DECISION DELEGATED TO DEVELOPMENT MANAGER

Application No: H13-0450-20 **Applicant:** Mr R Spenceley

Proposal: Demolition of dwelling and erection of 2 dwellings - approved under H13-0056-20. Amendments to include changes to the garages and re-position.

Location: Lea House 29 River Lane Moulton

LOCATION & SITE LAYOUT PLANS

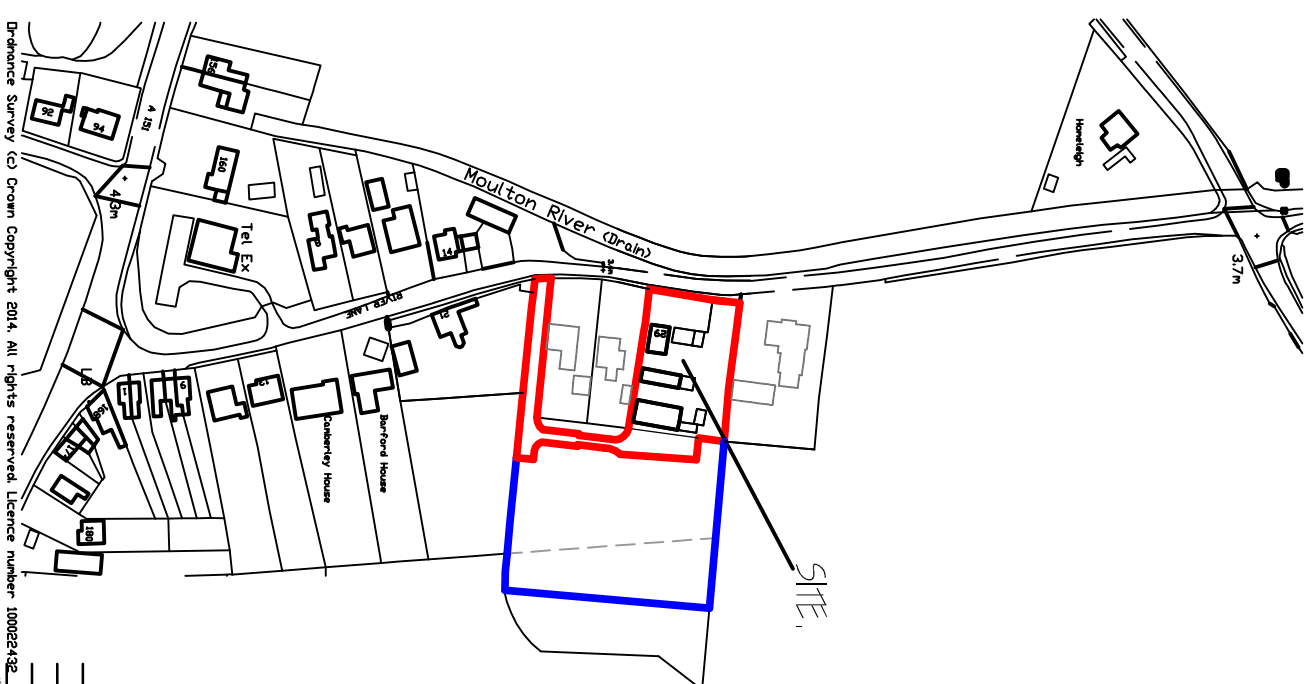
- The detached garages per each plot will be replaced for one party-wall large garage, one space per each plot.
- The layout of the independent driveways will be altered to extend the full width of the plots.

Although the approved garages mirror each other, the proposed amendment will provide further symmetry to the form of development than two separated outbuildings in the corner of each plot.

The proposed outbuilding will be set further (up to 7 metres) from the private shared drive than the approved garages. Thus, the separation to the dwellinghouses will be reduced from 15m to 7.25m and 14m to 6.35m in the northern and southern plot respectively.

As a result of the new garage, the independent driveways will be repositioned from the central fence that splits both plots to the length of rear boundaries of both plots.

On balance, it is considered that the proposed amendments will not undermine the design standards of the development. Neither any harm in terms of residential amenity is anticipated due to such alterations to the development.
